**New High School in Jerrabomberra (SSD-24461956)
Response to Submissions**

ATTACHMENT 1 – KEY ISSUES

REVISED DESIGN

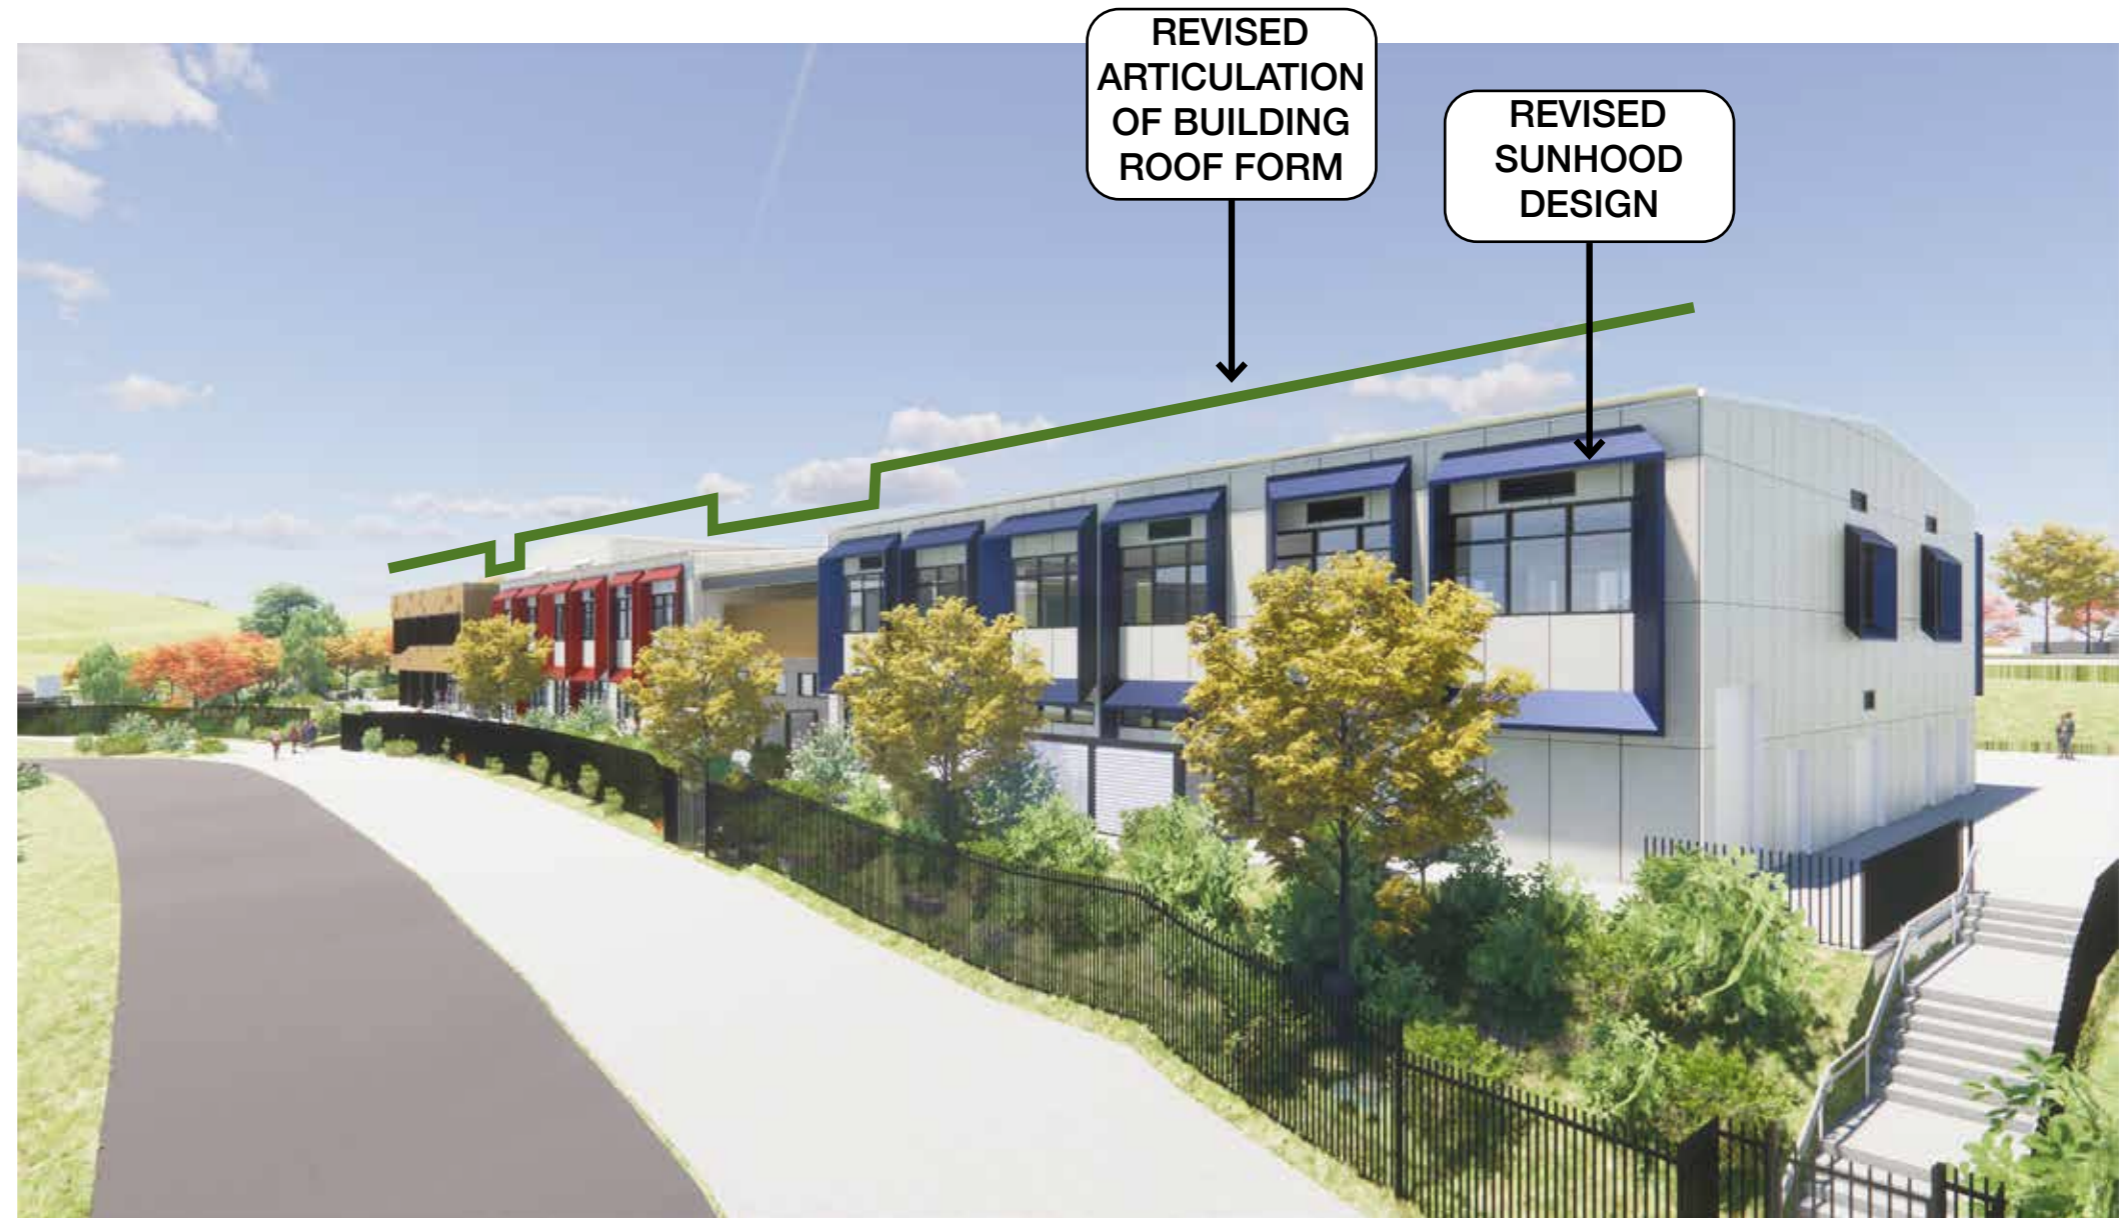
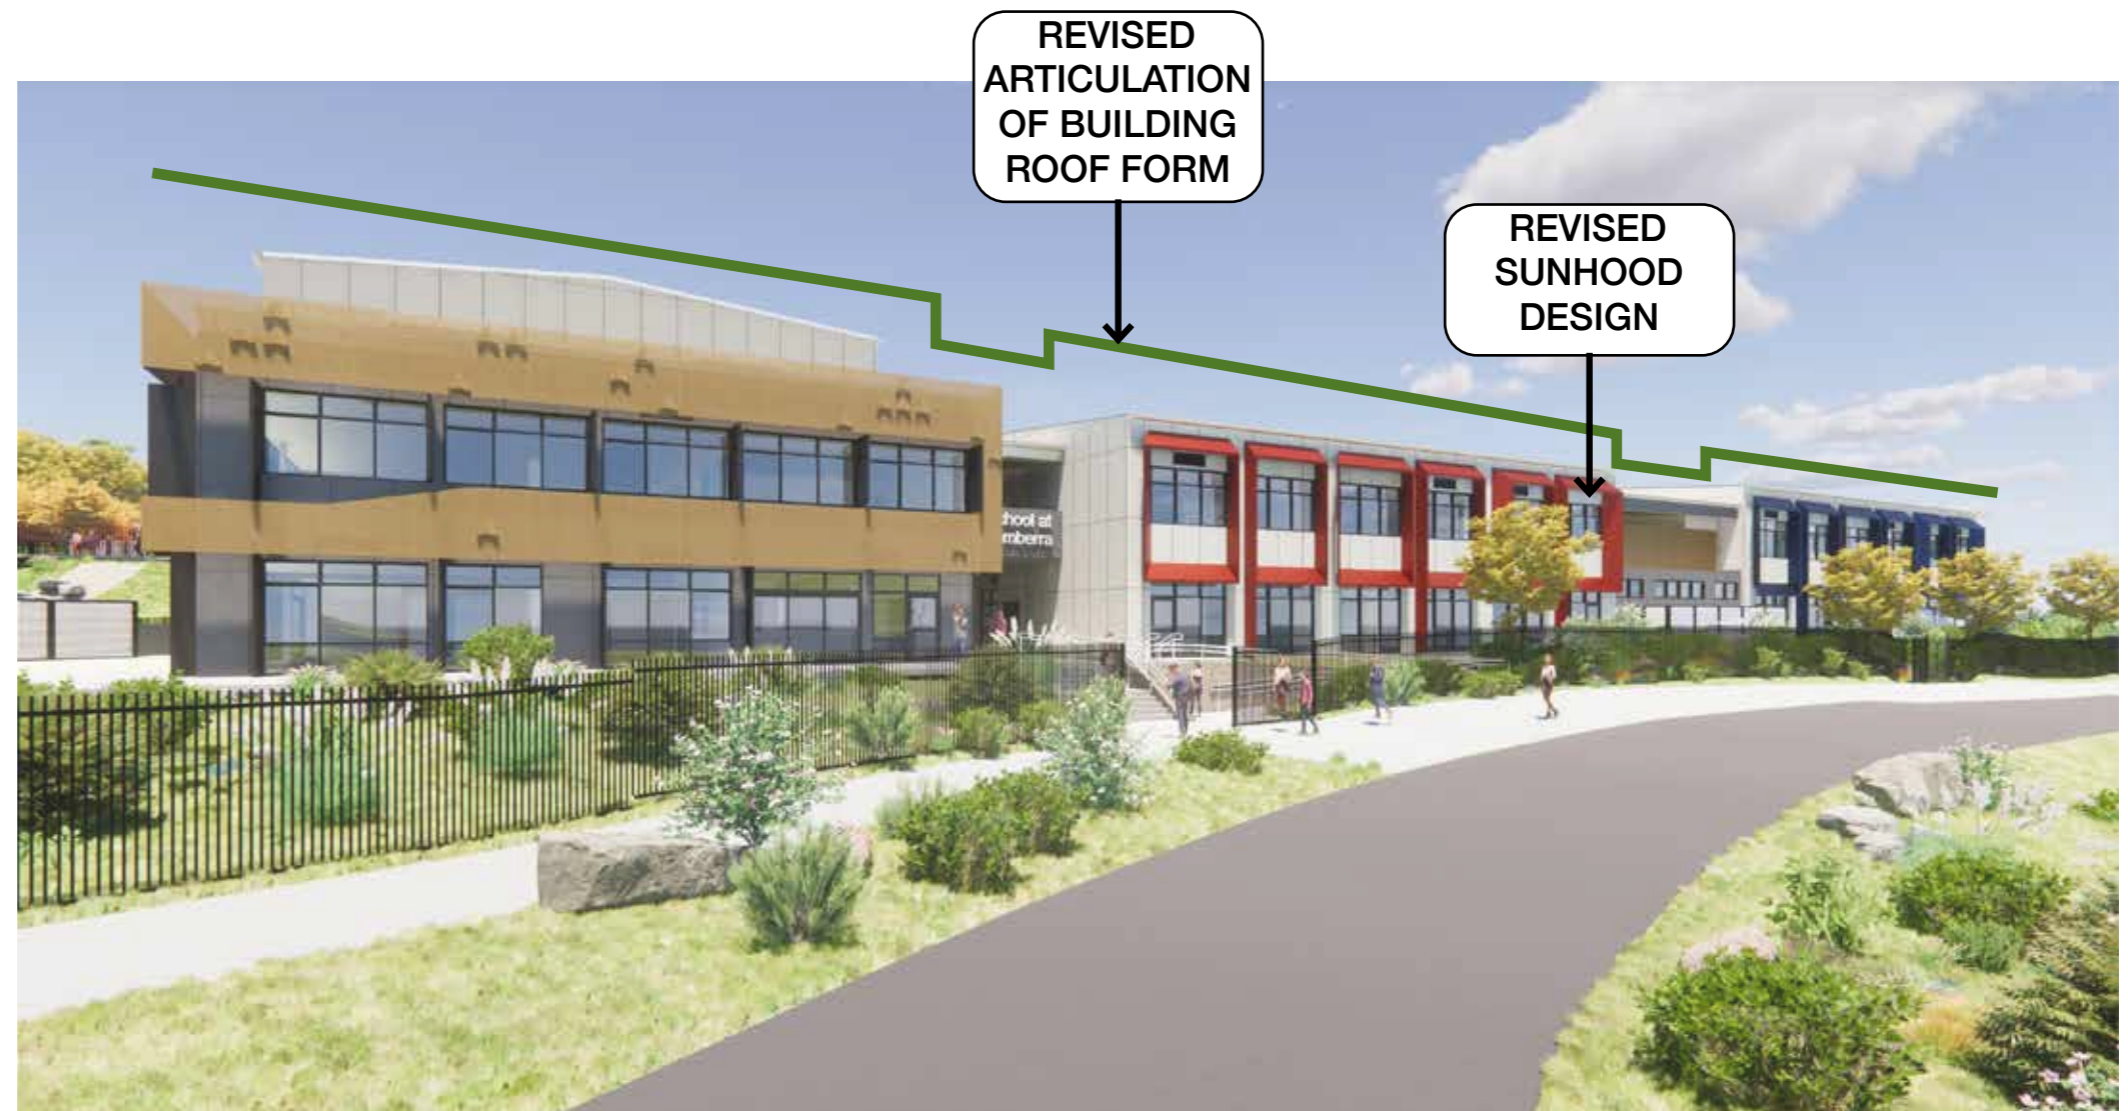
- *Recommendations 11 and 12a* – opportunities must be pursued to articulate the volume of Building A along Environa Drive to reduce the visual bulk and allow for more opportunities for natural ventilation.

ACCESSIBILITY VIA DAVID MADEW OVAL

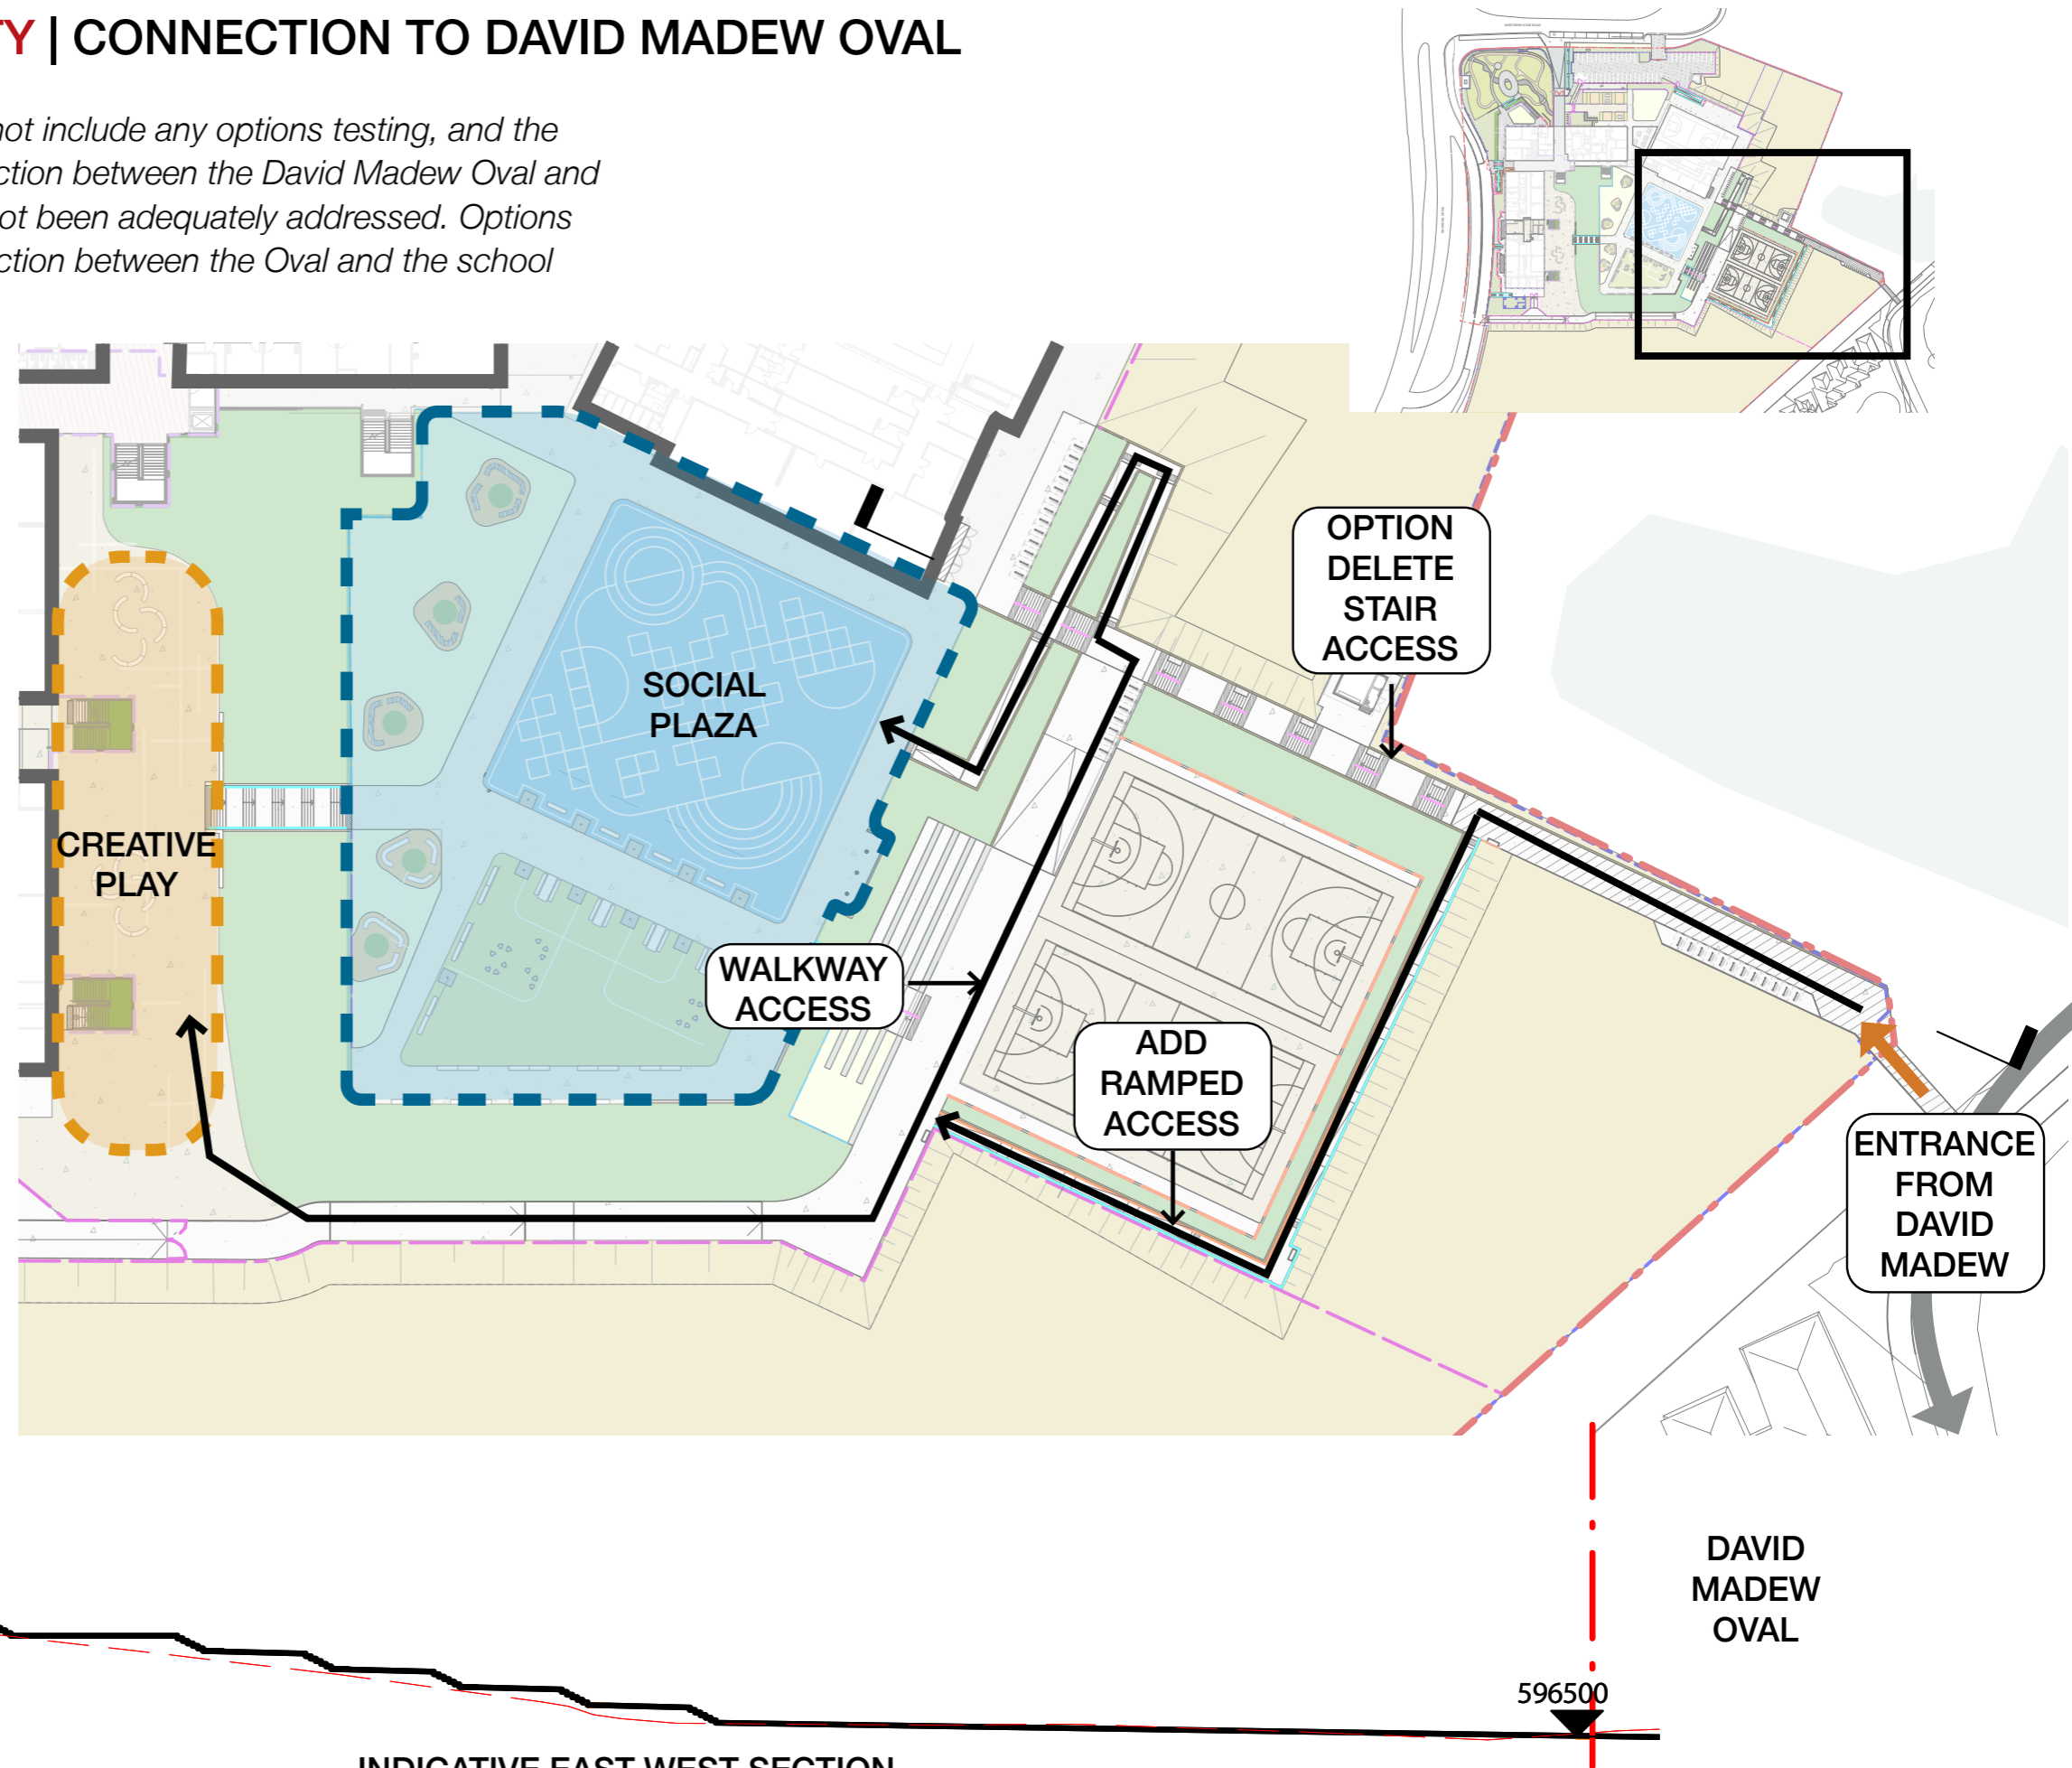
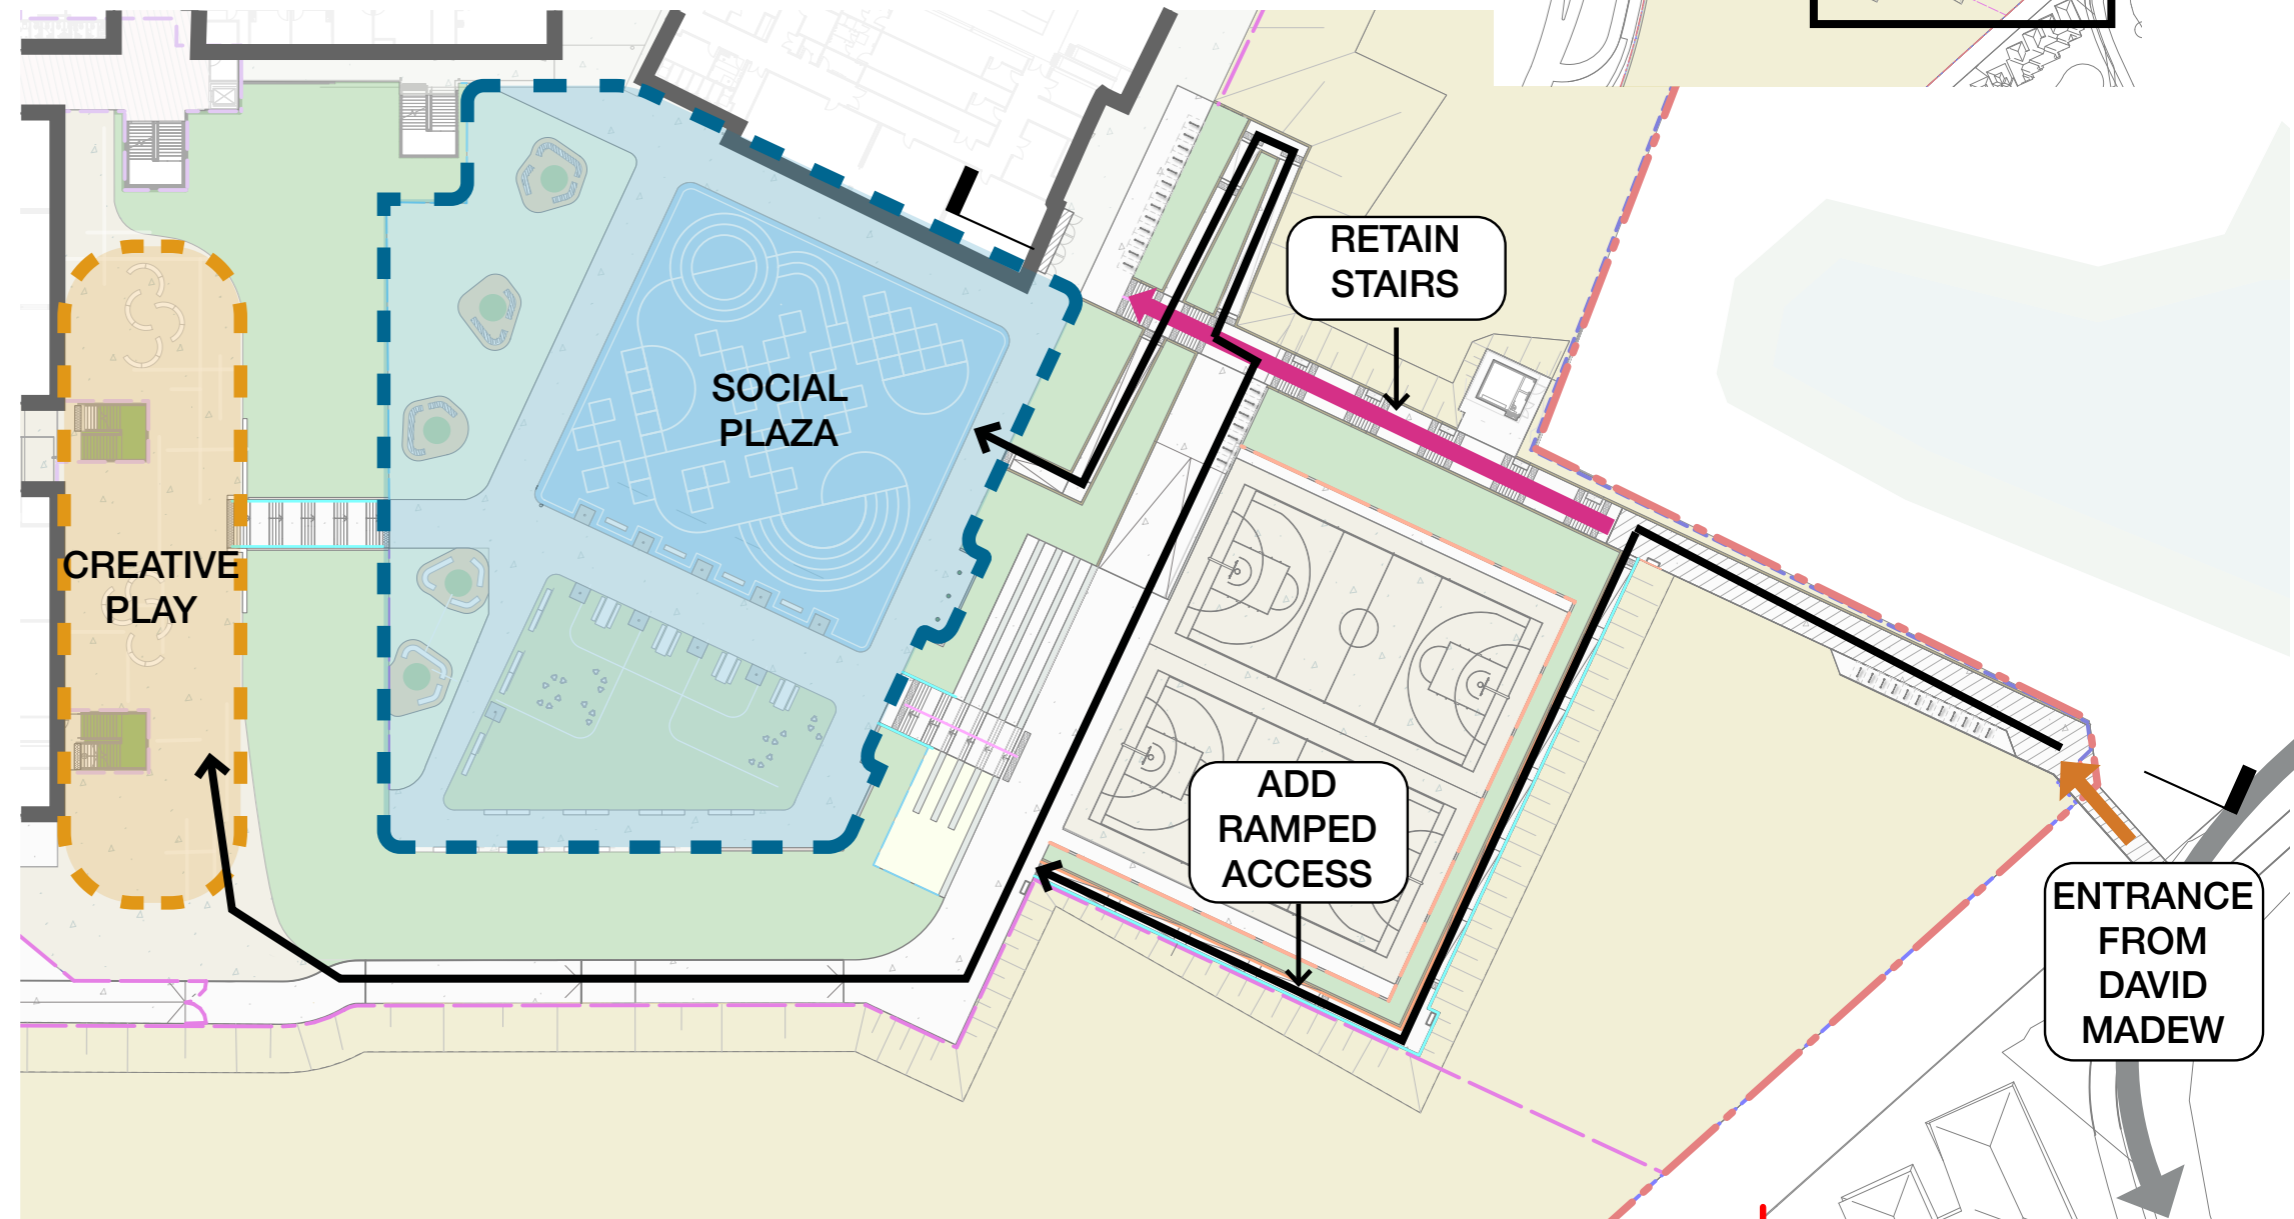
- The following recommendations of the SDRP advice must be addressed:
 - *Recommendation 7c* – the response does not include any options testing, and the recommendation to explore how the connection between the David Madew Oval and the school is connected and inclusive has not been adequately addressed. Options to provide an inclusive and equitable connection between the Oval and the school must be explored.
